Re: Your client, Bill Summers of MI Treehouse, LLC
RUE CAO 15-001
5637 East Mercer Way, King County Parcel No. 192405-9312

I am writing in response to your letter and Exhibits A through F, dated December 18, 2017, regarding your client's Modified Proposal for a Reasonable Use Exception for the above-referenced property.

Wetland and Wetland Buffer Impact Site Plan

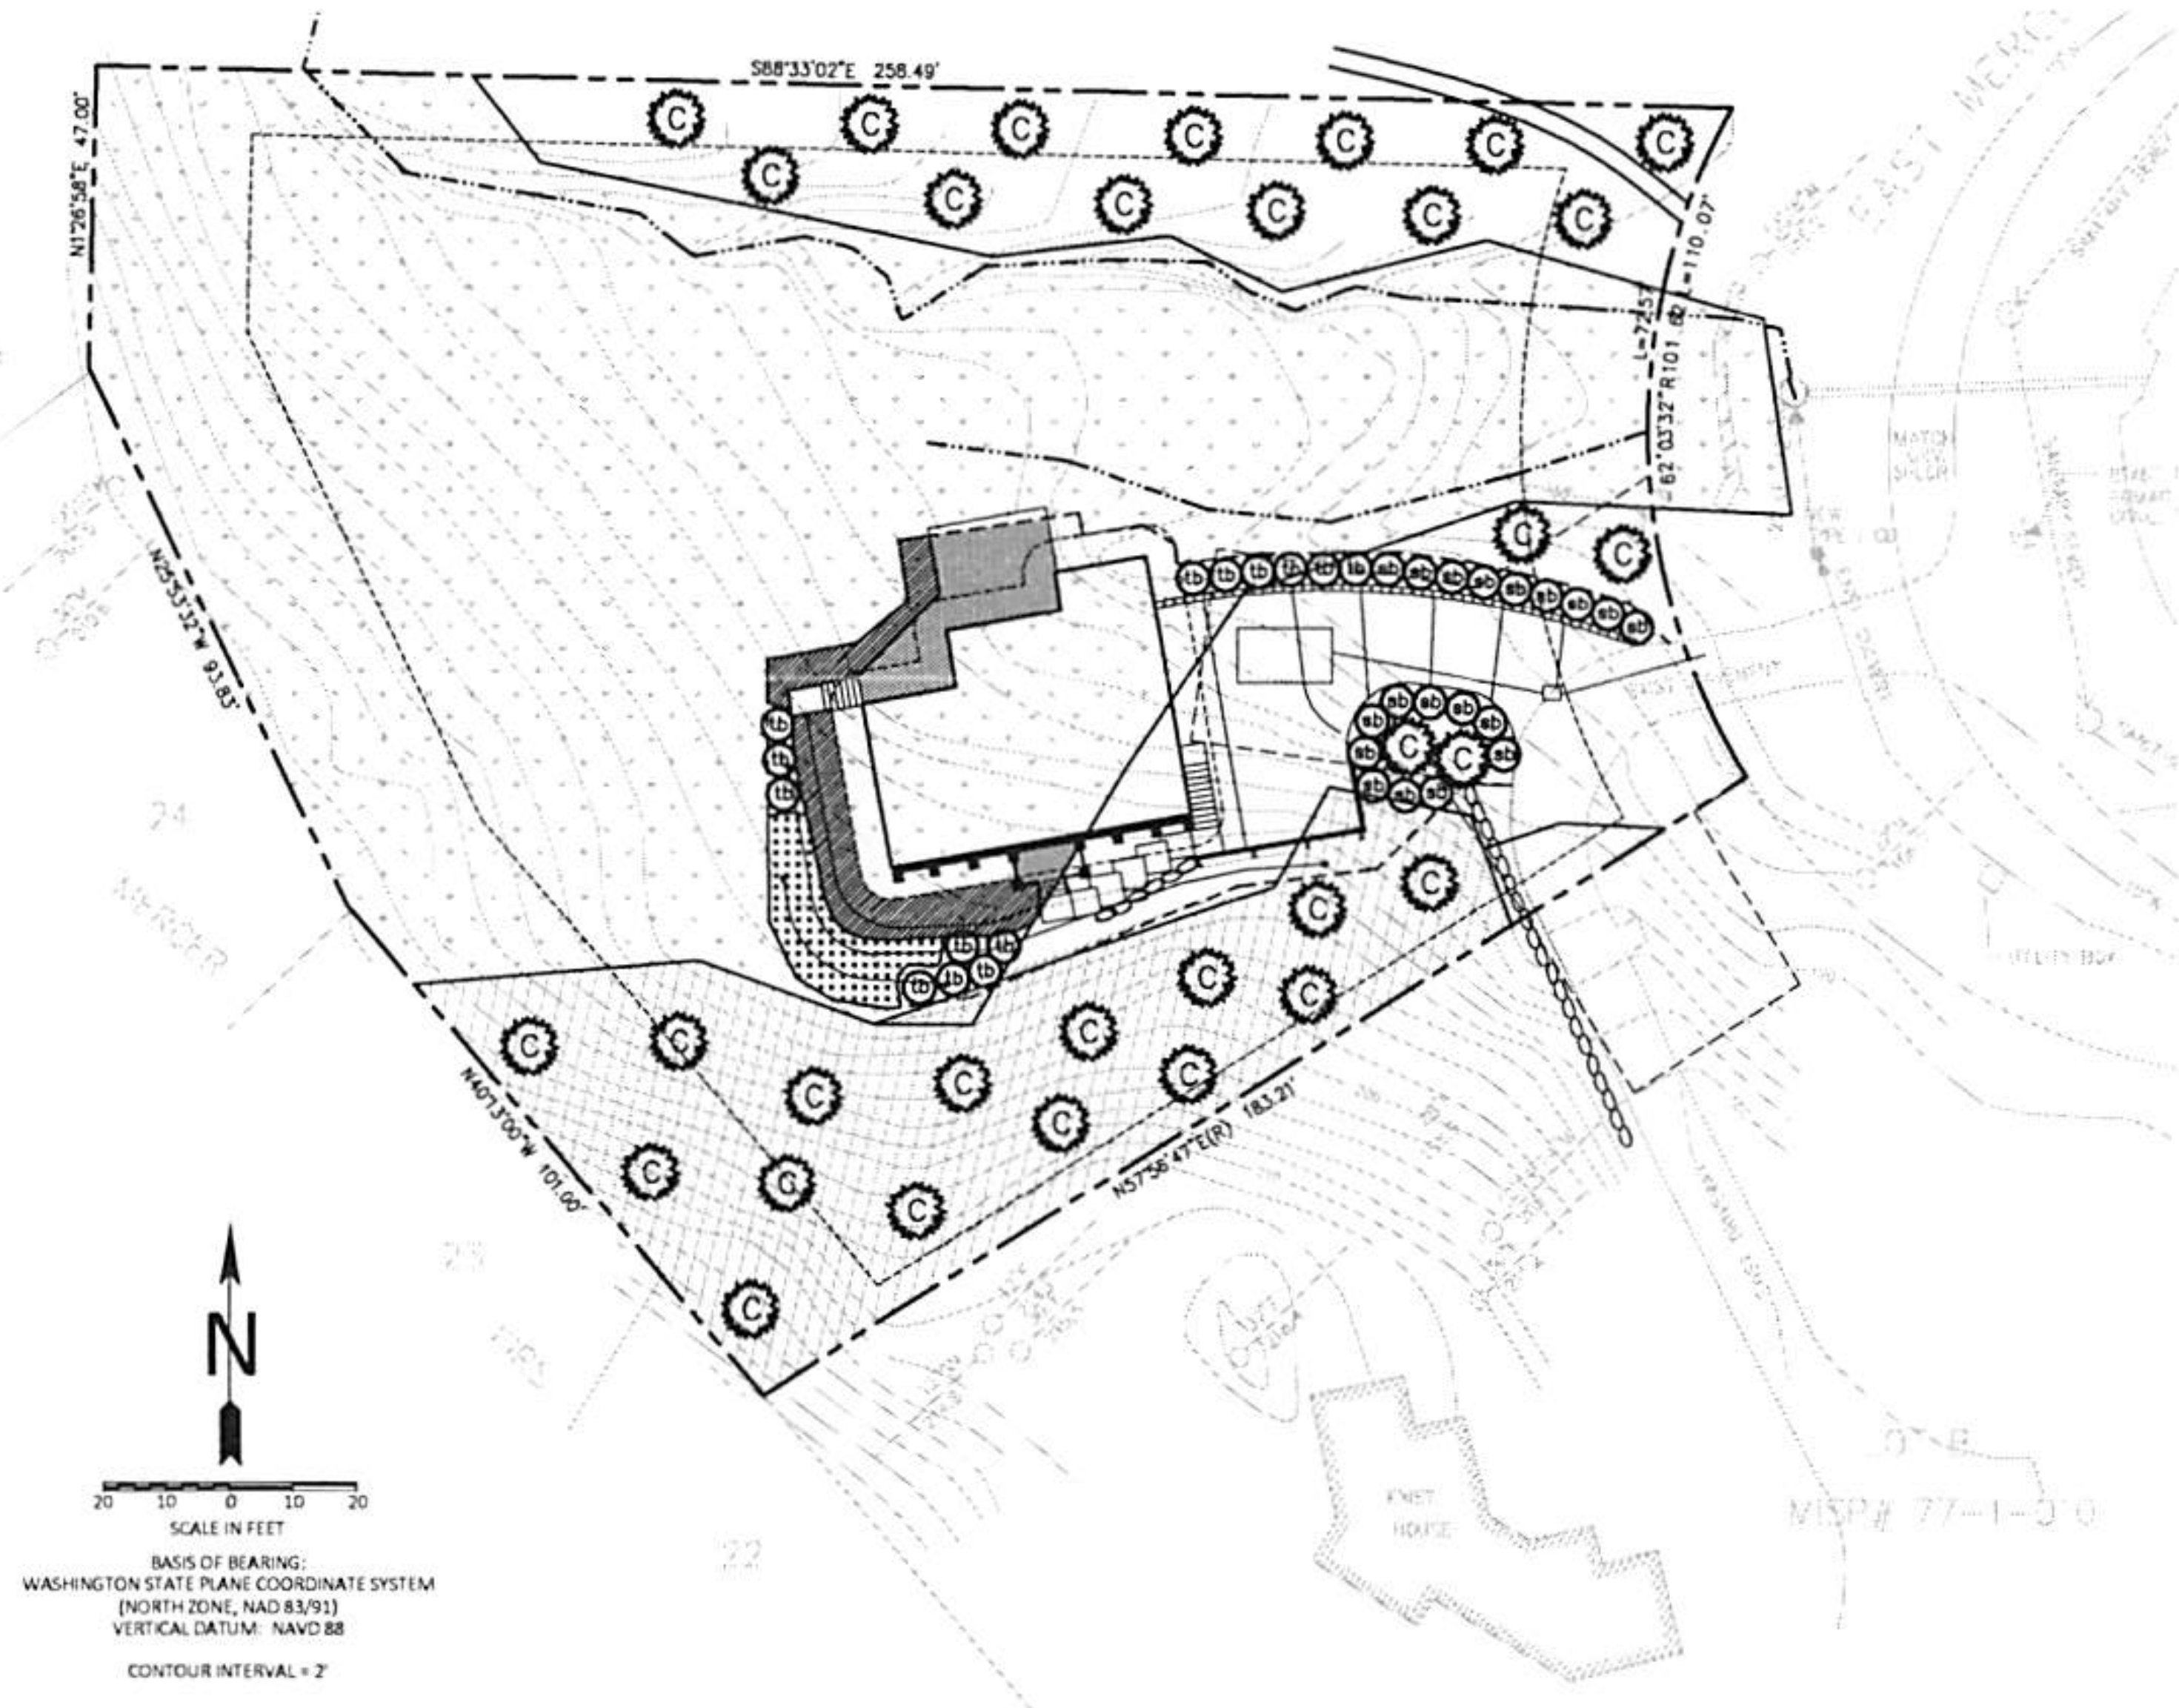
- B. Wetland / watercourse impacts.** The wetland / watercourse materials provided December 18, 2017, specifically Exhibits E & F, focus primarily on the appropriateness of the mitigation and generally support the idea of in-lieu-fee, off-island mitigation. Significantly, the material provided to date does not support the apparent conclusion that the Modified Proposal will result in less wetland / watercourse impacts as compared to the Initial Proposal. An updated critical areas report and revised site plans that include the following is necessary:

- 1) A delineation of the wetland / watercourse (with appropriate references to the flagged location of these features) on the site plans. The area of the wetland and wetland buffer should also be provided on the plans.

- 2) A description of the wetland, wetland buffer, and watercourse buffer impacts (*e.g.*, area of impact, type of impact (permanent / temporary)) associated with the Initial Proposal and the Modified Proposal.

E. Technical corrections. The proposed site plans should be revised for clarity and to accurately reflect temporary and permanent impacts to critical areas anticipated with the Modified Proposal.
